CITY OF ALBUQUERQUE

October 22, 2018

**Re: Overture Senior Active Adult
Erosion Sediment Control Plan
Engineer's Stamp Date 10-17-18 (D18E056A)**

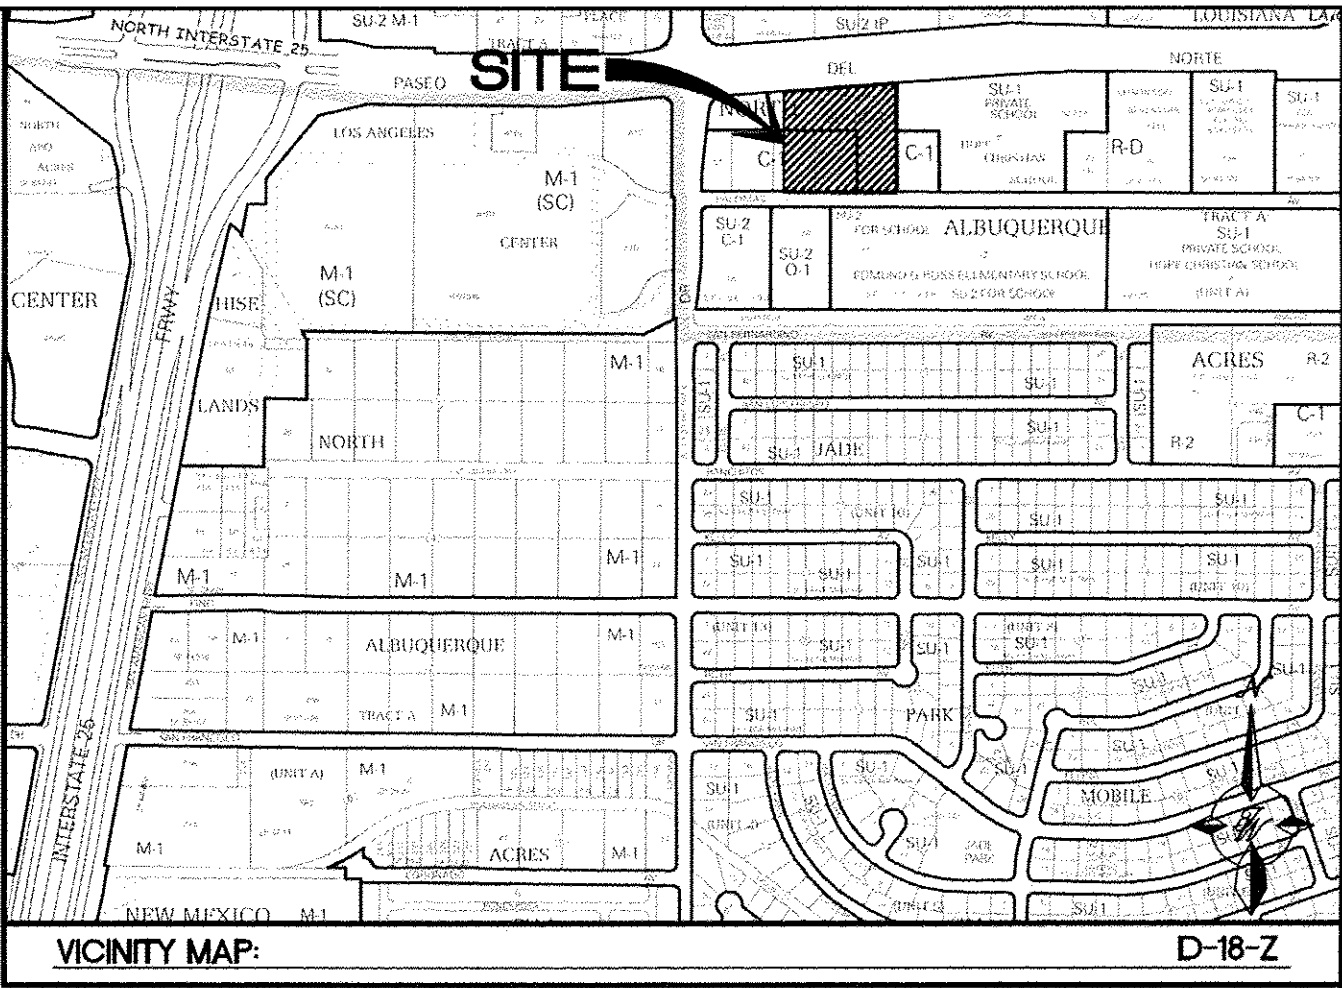
1. Provide proposed grades. The simplest way may be to superimpose BMPs on the grading and drainage plan.
2. Provide a BMP for the trenching activity on the lot to the west.
